MMC SP Review Mtg Feb 1, 2018 - MEETING NOTES

Key points from the Site Plan Review meeting with MMC held last **Thursday, February 1, 2018** plus (at end) future meeting agendas:

Here are the consolidated comments from last Thursday's preliminary review of the MMC draft Congress Street detour analysis dated 1/31/18.

Patient / Visitor Garage Traffic Control Plan

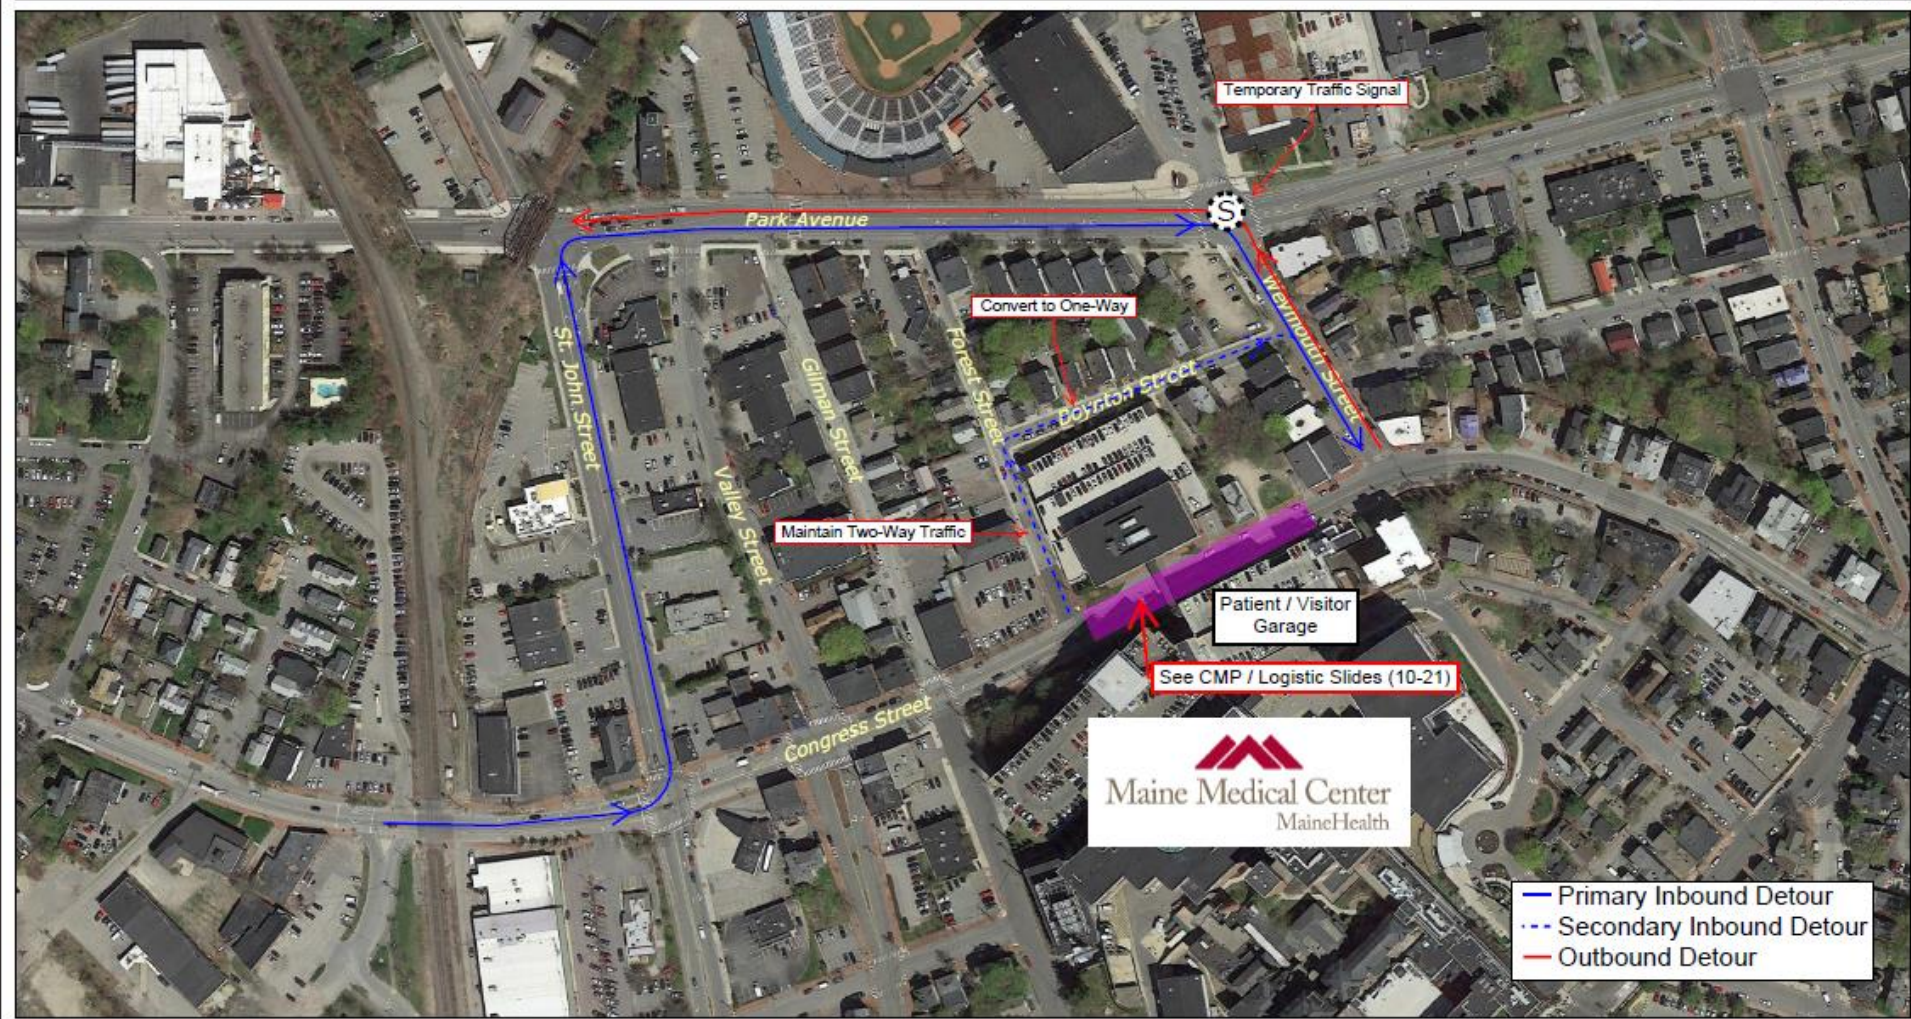
- The configuration and specific type of temporary traffic signal equipment proposed for the Weymouth Street/Park Avenue intersection and the means of traffic signal coordination/communication with nearby traffic signals

- The specific location, placement and wording of detour signage associated with the proposed detour concept
- The specific recommended deployment of personnel (e.g., flaggers, police officers, etc) at the initiation of the proposed Congress Street detour to actively manage traffic associated with the detour and and coordinated with construction activities/the CMP.
